Hornsea Four Offshore Wind Farm

In lieu of attendance at the Hornsea Project Four Issue Specific Hearings (ISH) week commencing 18th July 2022, Natural England provide updates in Appendices 1-3 of this letter in relation to the published agendas for ISH 10, 11 and 12. We hope this will help facilitate the ISH by identifying those issues which Natural England considers have been resolved or are progressing towards resolution, and those issues with outstanding concerns – and therefore are those that the ISH could usefully focus on. Our full comments and updated Risk and Issues Log will be provided at Deadline 6.

Appendix 1: ISH10 on Marine processes and ecology (excluding ornithology)

Figure 3: 1979 and 2011 bathymetries of Smithic Bank (top and middle) and a comparison of the 1979 and 2011 bathymetries (bottom).

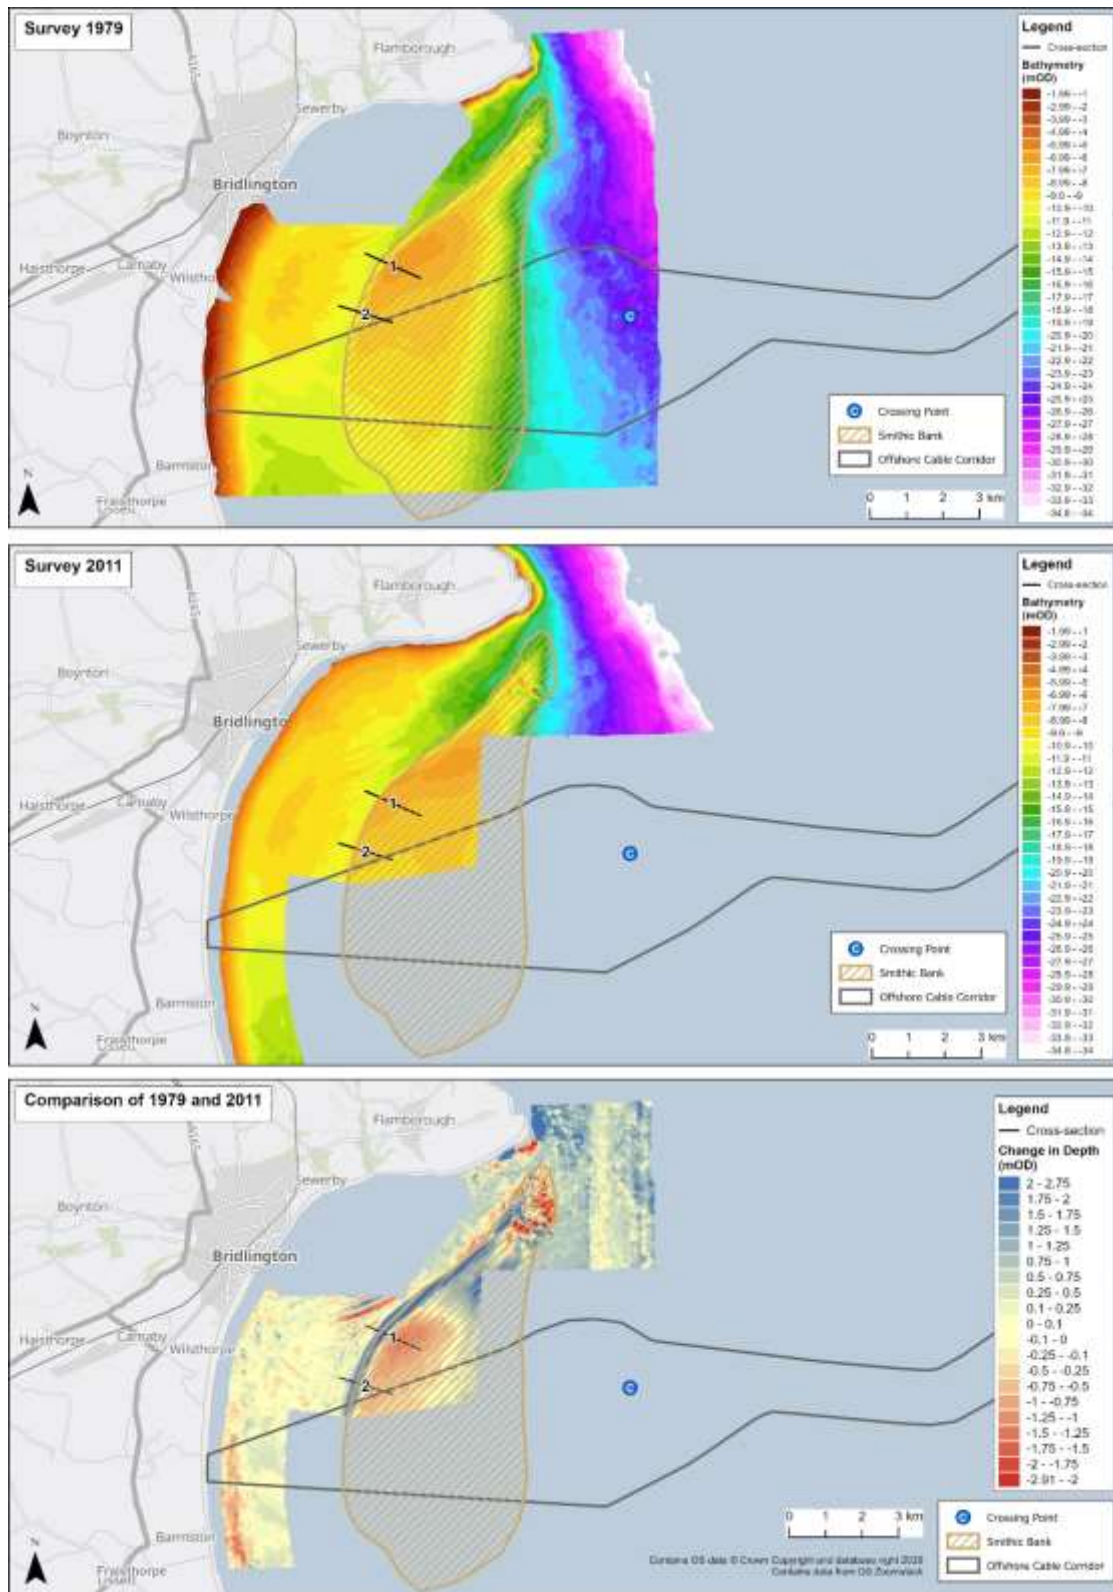
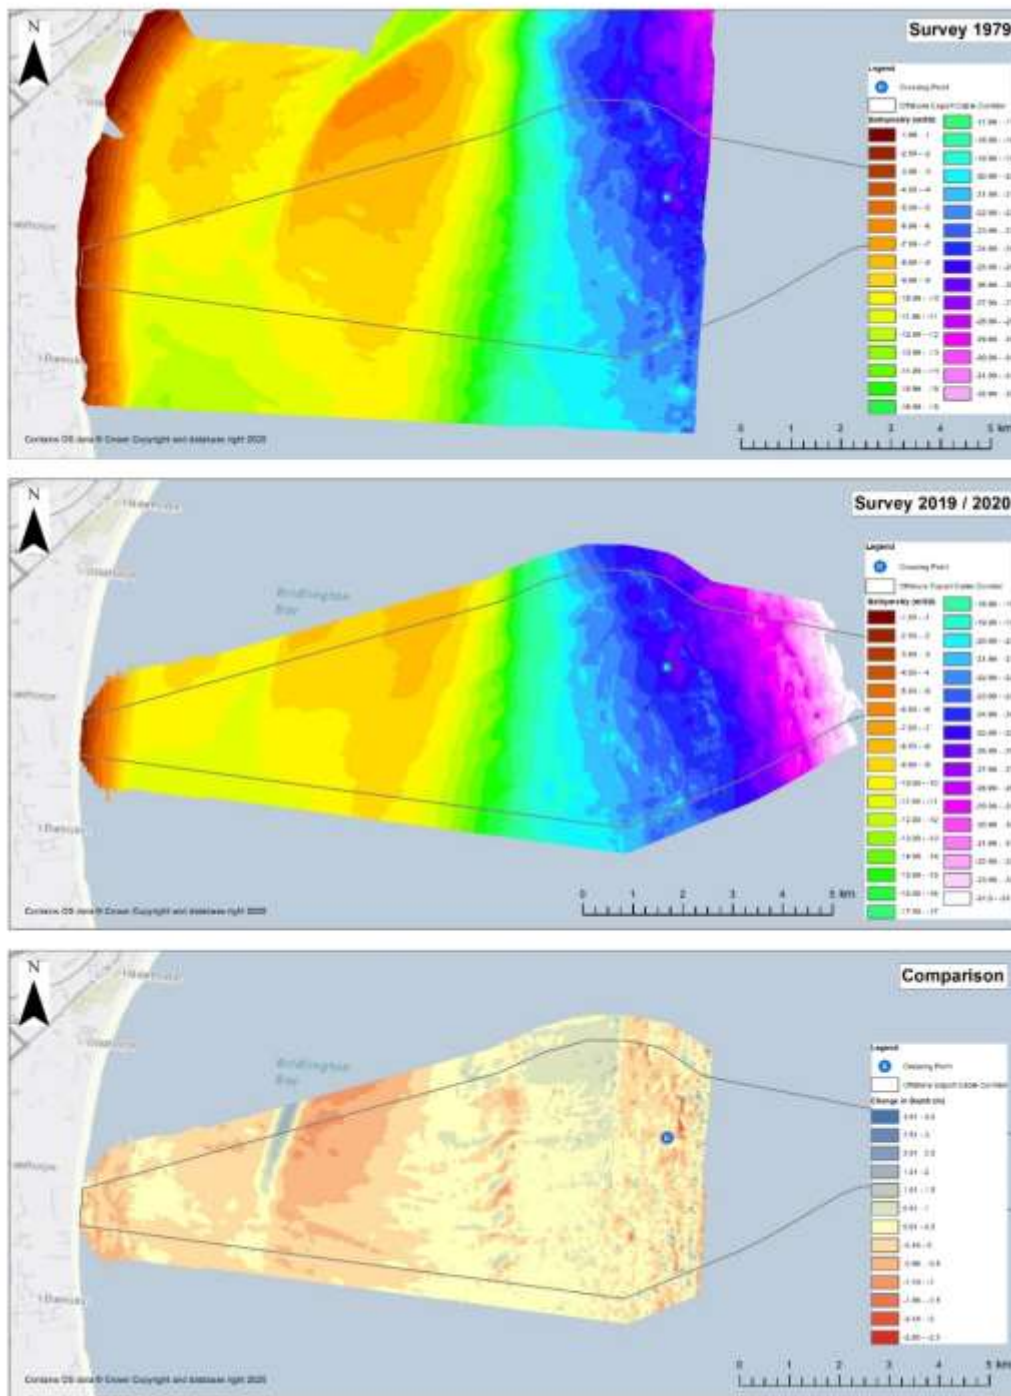
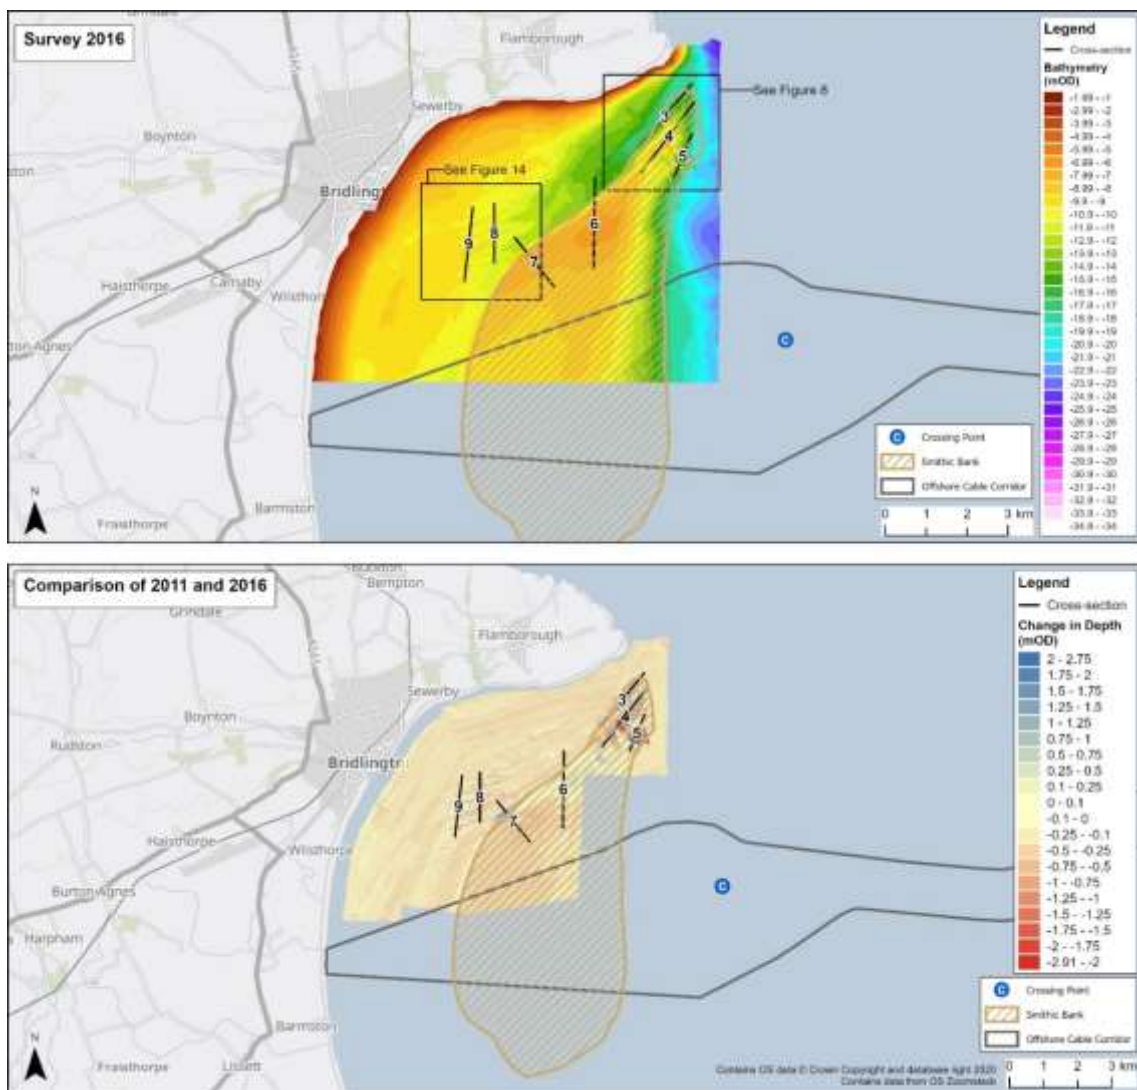
<p>Smithic Bank Monitoring Natural England welcome the proposal to monitor the cable corridor from the Dogger Bank cable crossing across Smithic Bank to the coastline REP5a-017 (G5.33). However, we advise high-resolution swath bathymetry, total seabed coverage surveys, of the Order Limits Area between the Holderness Coastline and Smithic Bank, between Smithic Bank and the Dogger Bank A&B Cable Crossing, and to 1km seawards of the Cable Crossing are all required. This is to confirm the conclusions of the ES that: (a) cable installation will have no detrimental impact on the sandbank (in terms of accelerated sandbank lowering or migration); and (b) any impacts from multiple cable remedial and maintenance activities over the lifetime of</p>

<p>the project will not lead to morphological change of the sandbank.</p> <p>The first step in this monitoring plan should be a pre-construction survey, in order to establish a robust and accurate baseline. This should then be followed by a post-cable installation survey every 6 months for 2 years (including two winters periods and one summer) and further surveys every 5-years for the duration of the project. Comparison reports should be produced, incorporating a comparison with existing bathymetric survey data (as presented in G4.9 Supplementary Report). These will enable qualification and quantification of any volumetric and spatial extent changes to the sandbank.</p>	
		<p>Flamborough Front</p> <p>Natural England welcome the commitment to further reduce the MDS for the number of GBS structures, however our position remains that GBS should not be used within this site.</p> <p>Although the potential for significant impacts/AEoI would remain with the alternative foundation types, we would have much greater confidence that additional measures could be incorporated to reduce the risk.</p> <p>A key concern is the underestimation of the spatial extent of wake/plume interactions due to monopile/pin pile foundations. Evidence from other OWFs in the North Sea has shown the potential for wakes to extend > 1km and for wake-to-wake merging to occur (see Foster, 2018). We have not been able to confirm array layout as the Applicant has not yet provided full details of their design. Therefore, we advise that the Applicant should carry out a further assessment of wake and plume lengths based on their final layout plan and that this should be submitted alongside the layout plan for discharge. The layout plan should then be subject to a full assessment by the MMO in consultation with the appropriate SNCB and Cefas.</p> <p>Adequate post construction monitoring is vital to the validation of predictions and conclusions made at the time of application and within this refined assessment.</p>

Figure 30: Location of Hornsea Project Four offshore array area relative to potential northerly and southerly positions of Flamborough Front idealised from a number of datasets (Figure 22, Figure 23 and Figure 24).

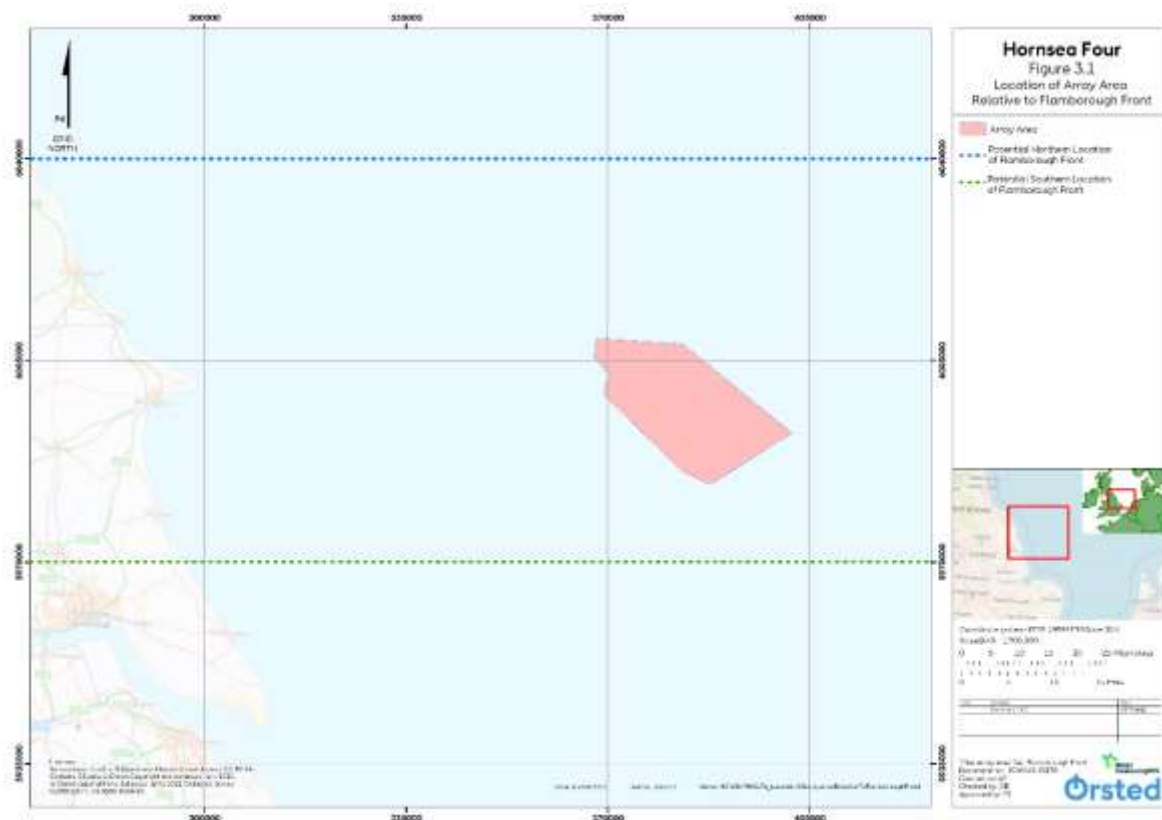
<p>strategy for the lifetime of the project.</p> <p>The initial step to monitoring proposed in G5.33, aims to assess changes to stratification at three locations within the array This is useful in terms of understanding small-scale physical processes, but it would be difficult to identify three locations that are representative of the whole array based on this plan. Therefore, we advise that the first step should be to use high-resolution satellite imagery to examine wakes, sediment plumes, and chlorophyll concentrations across the array and the wider zone of impact beyond the array. We recommend this monitoring should cover a temporal period to include the build-up of seasonal stratification through to breakdown of seasonal stratification. Secondly, the array-scale monitoring should be used to identify representative locations for the near-field monitoring of changes to stratification. Further consideration is also needed of the sub-surface/mid water chlorophyll concentrations. Over the long-term, there is a need to carefully consider monitoring changes to stratification, currents, suspended sediment concentrations, pH, turbulence, and chlorophyll.</p>
